**KIRKLEES METROPOLITAN COUNCIL
INVESTMENT & REGENERATION SERVICE**

**DELEGATED DECISION FOR DISCHARGE OF CONDITION A.4 -
NOTIFICATION OF A PROPOSED ENLARGEMENT TO DWELLINGHOUSE**

Reference no.	2020/HH/94127/E
Site Address	53, Thorncliffe Road, Staincliffe, Batley, WF17 7AS
Description	The proposal is for erection of single storey rear extension. The extension projects 6.3m beyond the rear wall of the original dwellinghouse. The maximum height of the extension is 4m, the height of the eaves of the extension is 4m
Recommending Officer	Tom Hunt

DRAWING TITLE	PROPOSED FLOORPLANS
---------------	---------------------

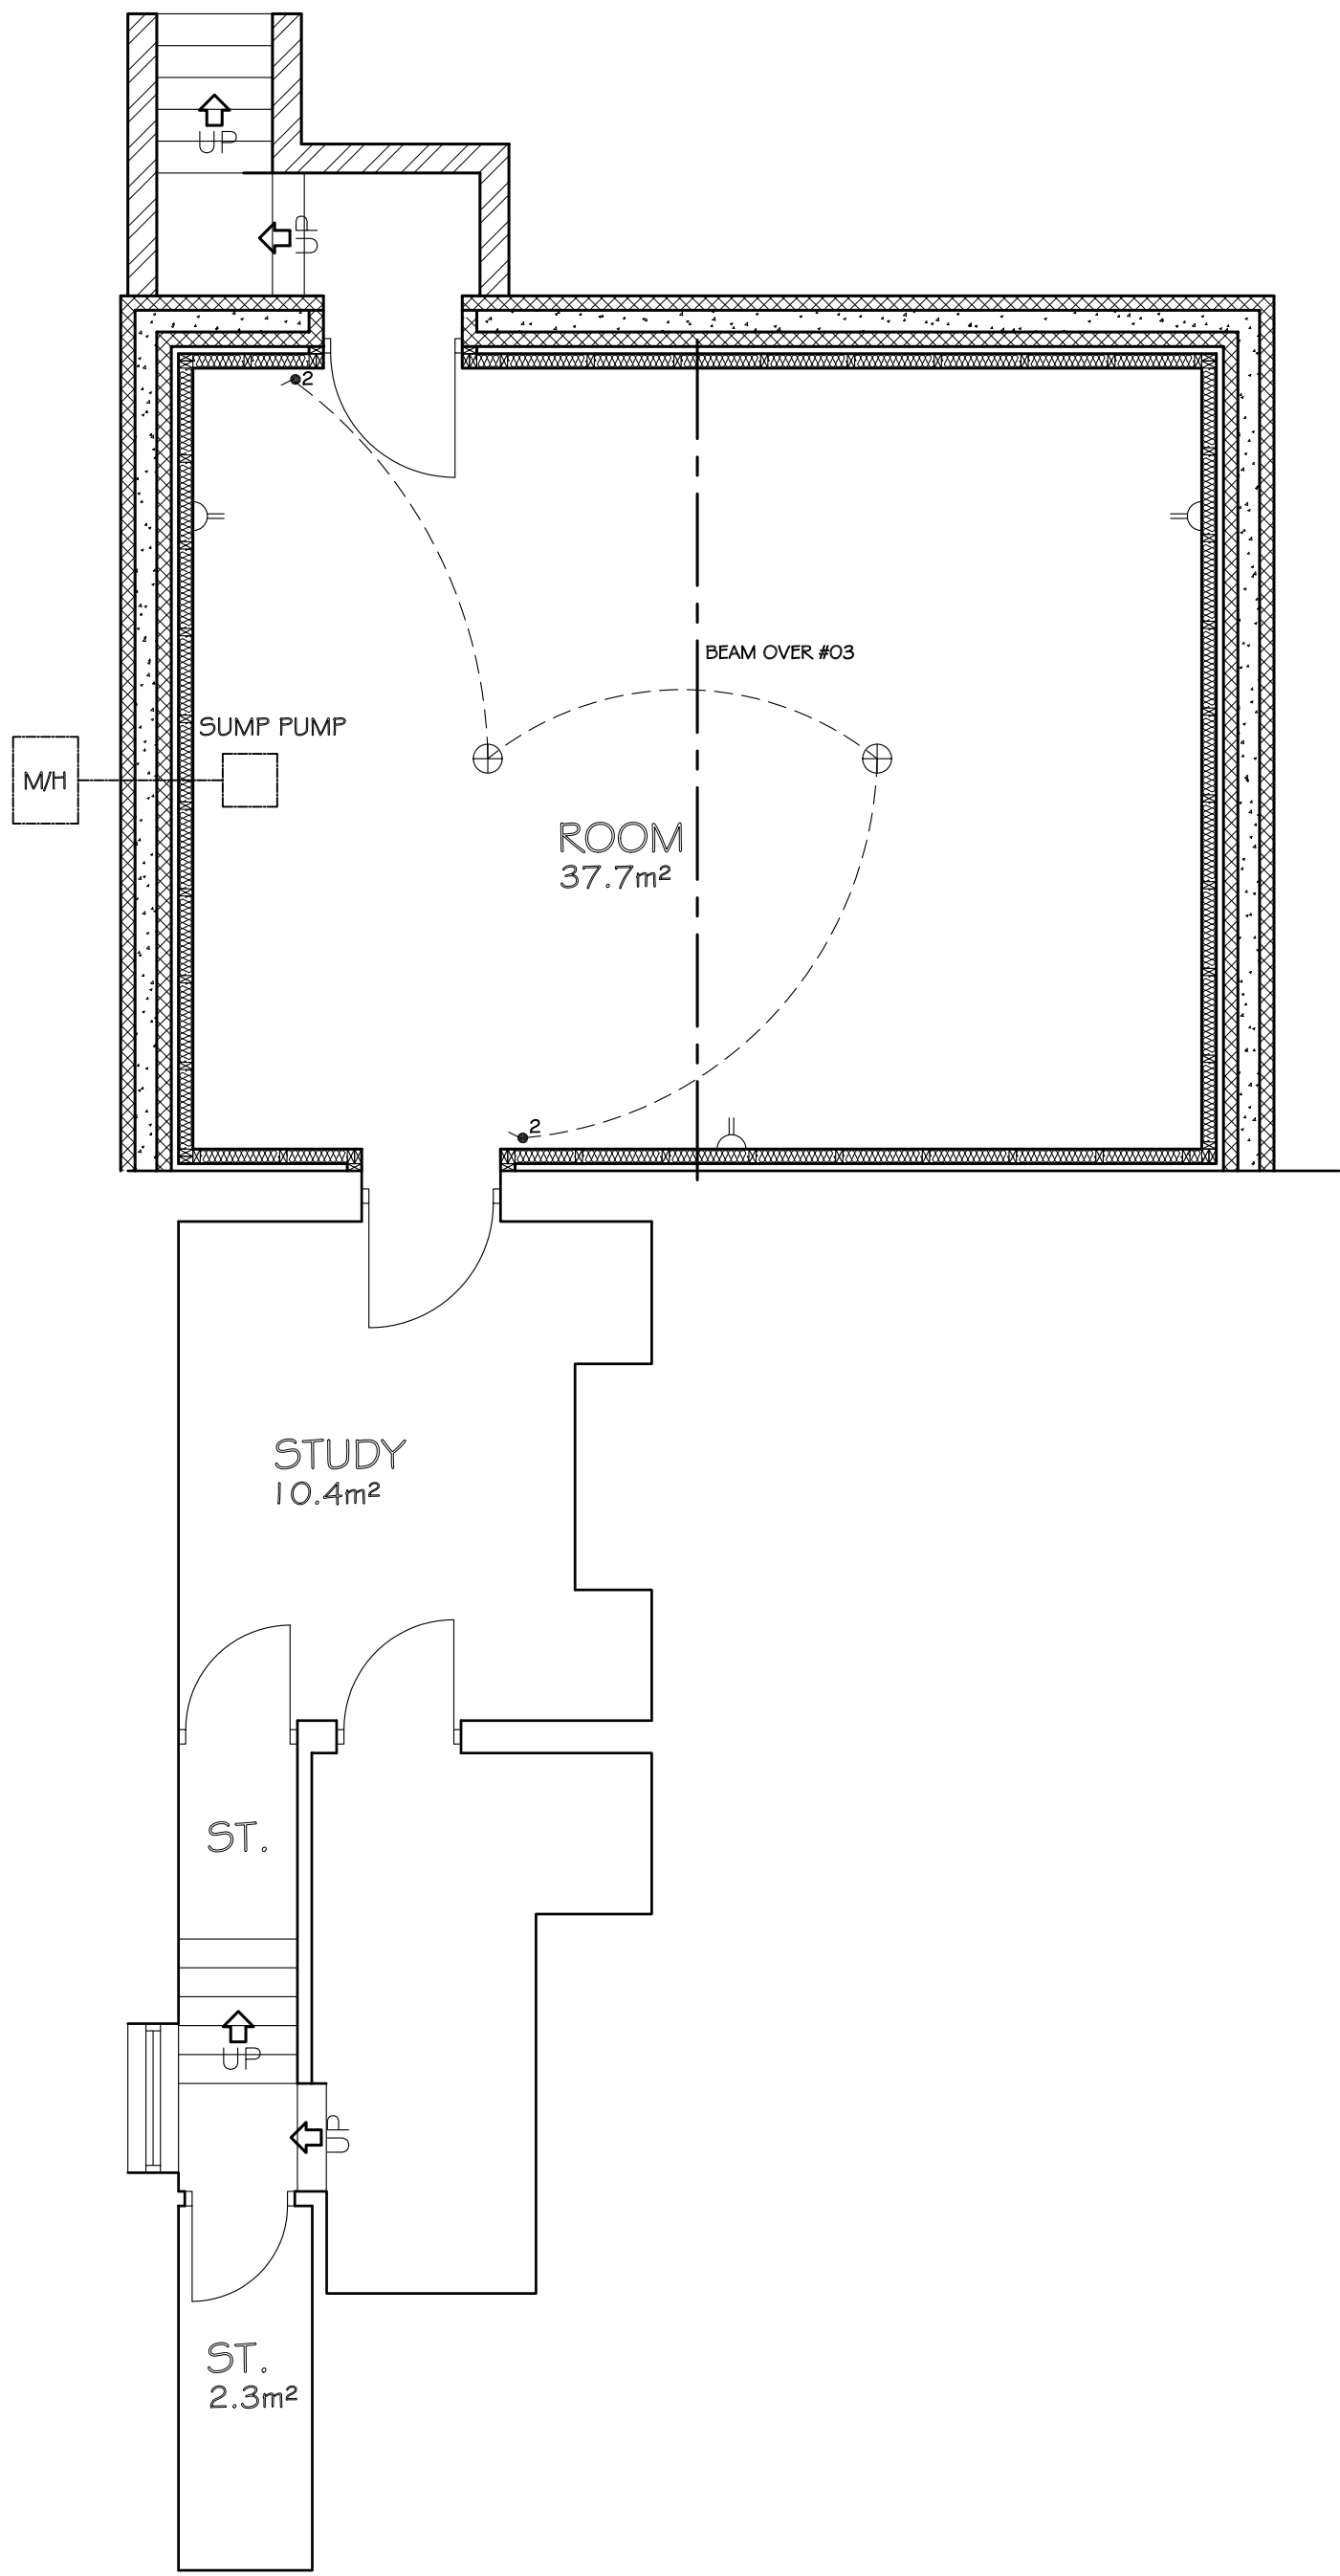
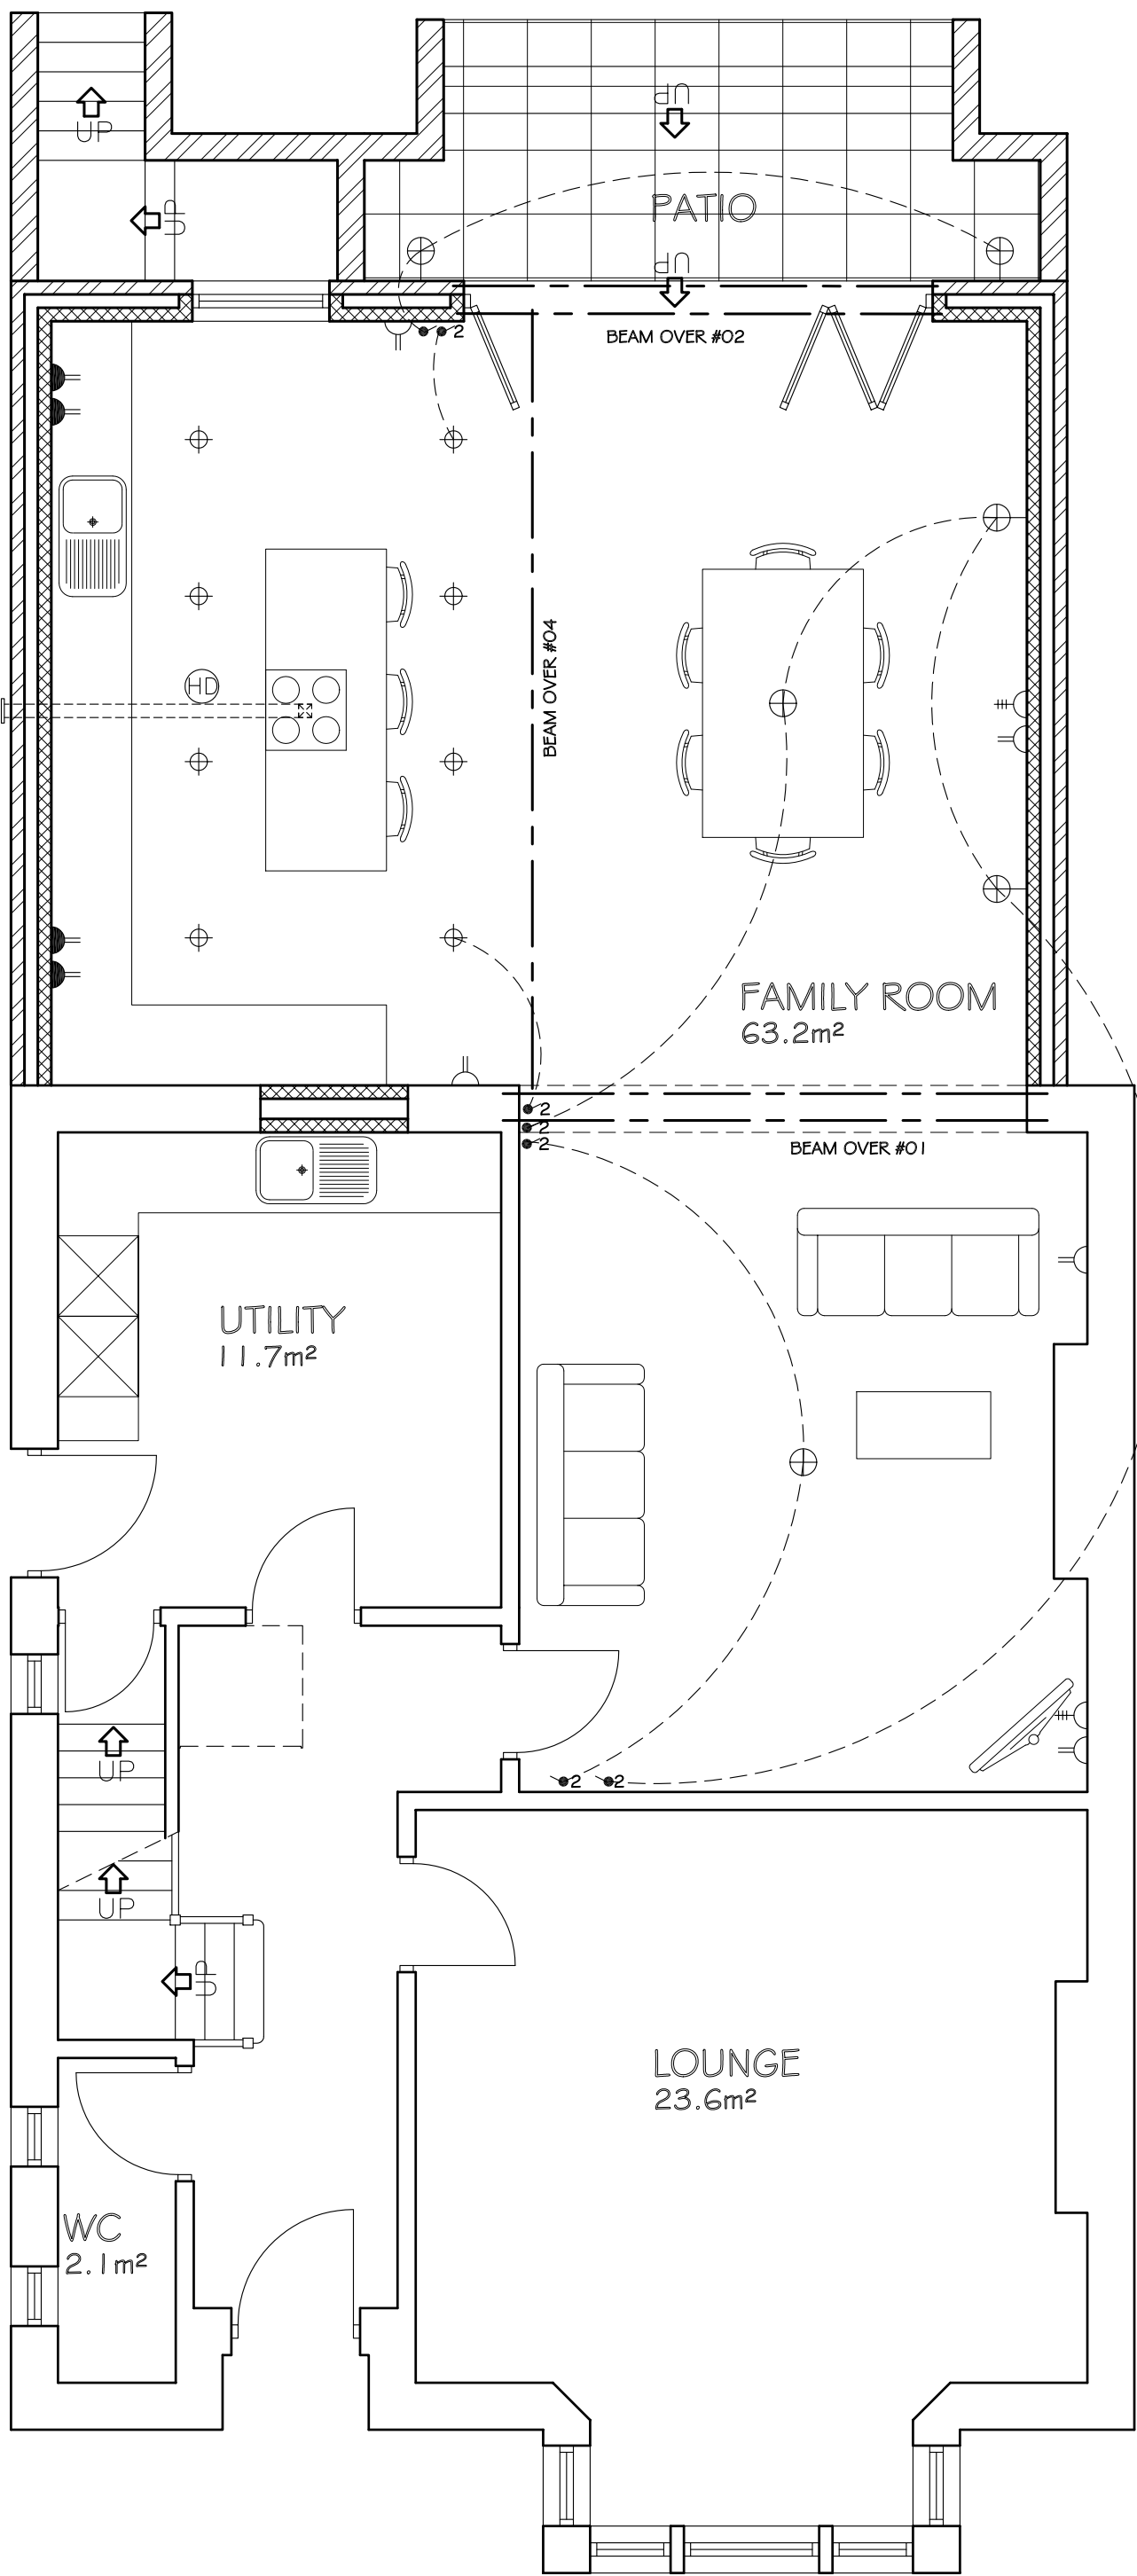
The proposal is for erection of semi subterranean two storey rear extension. The extension projects 6.3m beyond the rear wall of the original dwellinghouse. The maximum height of the extension is 4m, the height of the eaves of the extension is 4m.

The extension is 4m from the ground level however it has a lower ground storey which would mean a maximum height of 5.67m approximately.

The proposal would have a projection of 6.3m from the rear wall of the original dwellinghouse. The proposal therefore fails to meet the criteria of the General Permitted Development Order 2015, Schedule 2, Part 1, Class A paragraph h).
